Our Ref: NW/ARU/17/29C

RE:- Lillies, Yapton Road, PO22 0AY

Thank you for your correspondence of 9th March 2018, advising me of an Approval of reserved matters following outline consent BN/32/15/OUT relating to appearance, landscaping, layout & scale for erection of 38 No. dwellings including open space, landscaping & new access (resubmission following BN/28/17/RES) for which you seek advice from a crime prevention viewpoint.

DRAWING
Plots 12-13
Floor Plans

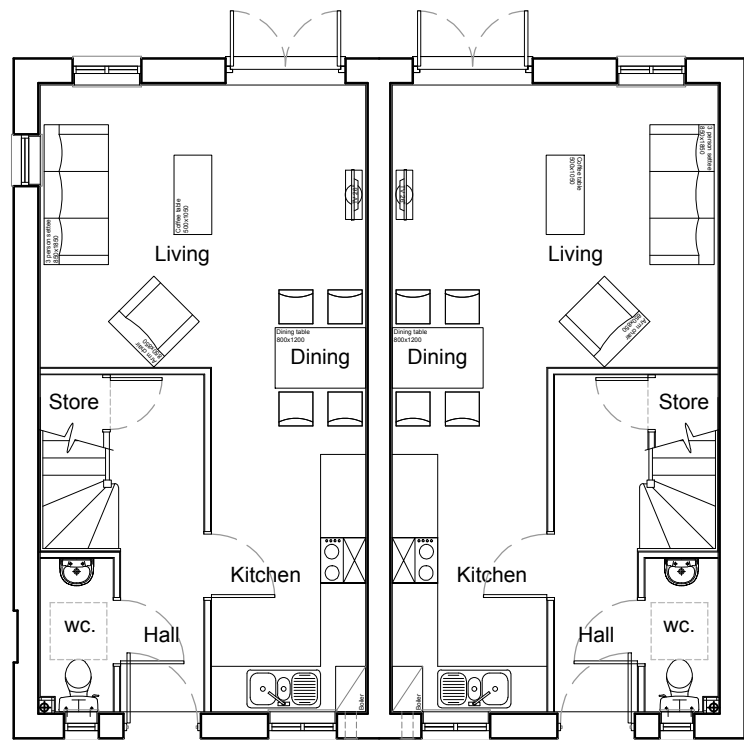
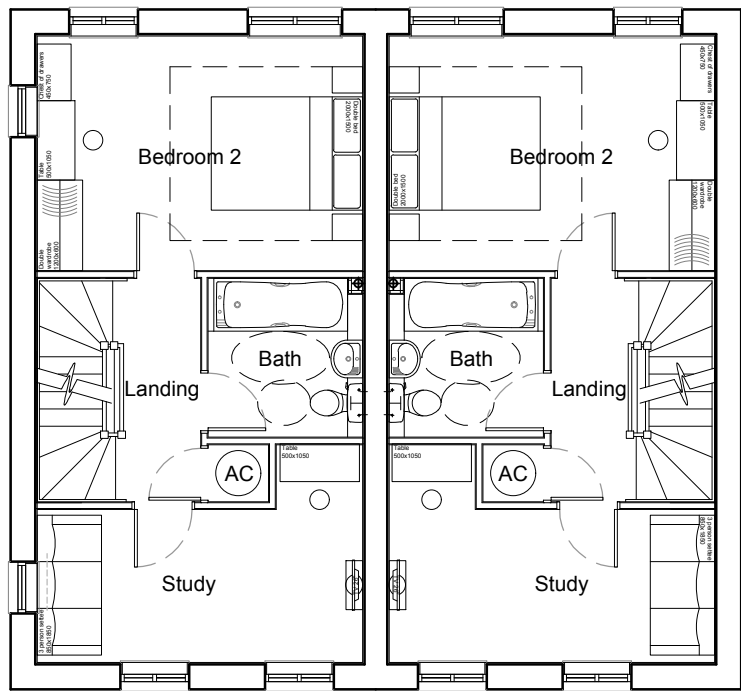
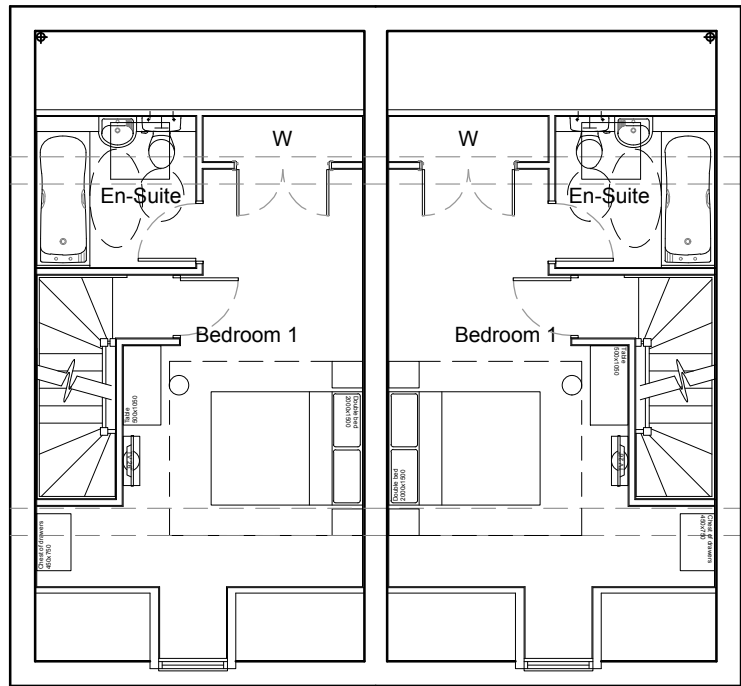
From a crime prevention point of view I am pleased to see the application has considered some security measures, but would prefer to see evidence of secure cycle storage facilities in dwellings that have no garages. Such as Plots 37-38, 1&2, 12&13, 14&15, 16&17, 18&19.
